Our reference: LIC07/1790-02, DOC11/8836
Contact: Chris Burton, 02 6022 0609

Re Modification to Project Approval No 07-0078 - Rockley Falls Quarry Holbrook

We understand that the purpose of the modification is to construct and operate a wet-mix batch plant and to extend the operating hours for the production of concrete for the Hume Highway Woomargama Alliance (HHWA).

We have reviewed the report titled *Rockley Falls Quarry, Request for modification to the approved project, wet-mix batch plant and extended operational hours* dated February 2011 and provide the following comments for your consideration.

■ **Figure 2: Schematic of the proposed wet-mix batch plant**

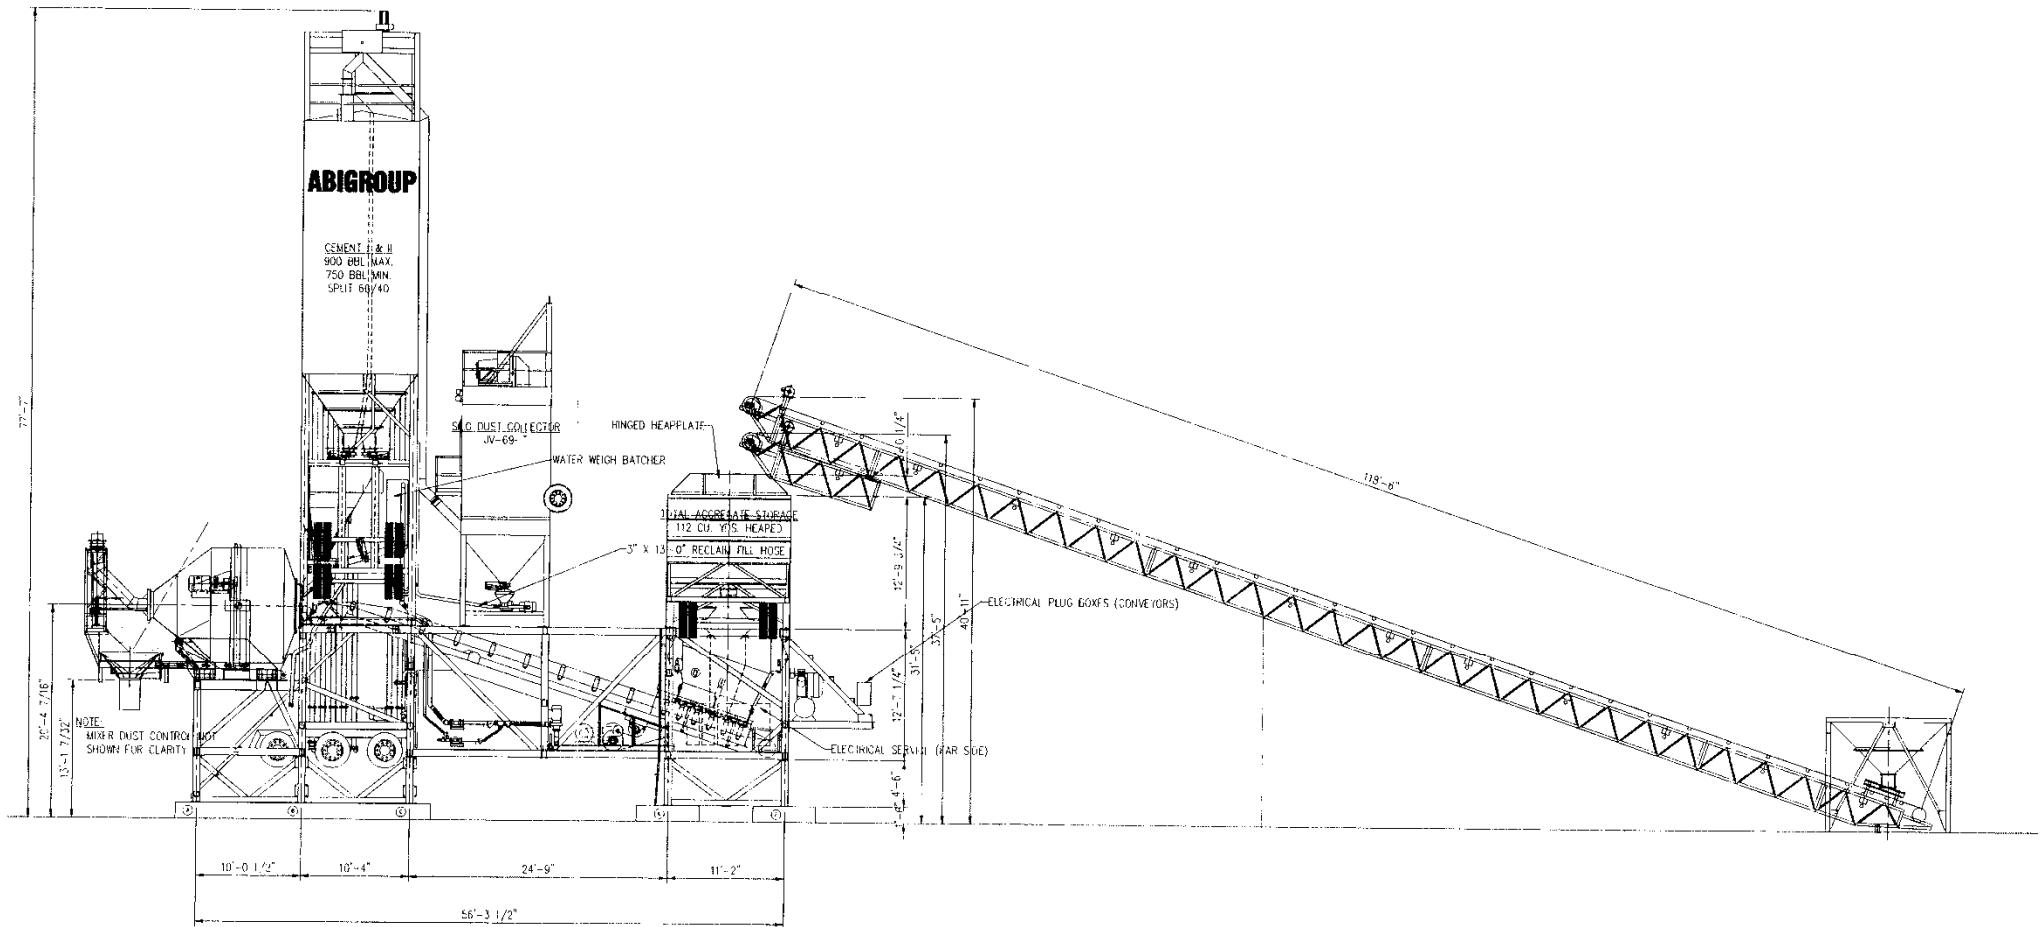
It is anticipated that up to 2,000 litres of wastewater will be generated each day from mixer bowl washout. This water must be retained in settling ponds and not discharged to surface waters until testing for suspended solids and pH is undertaken and the licence limits achieved. The licence limits for discharge are 50 milligrams per litre for total suspended solids and 6.5-8.5 for pH.
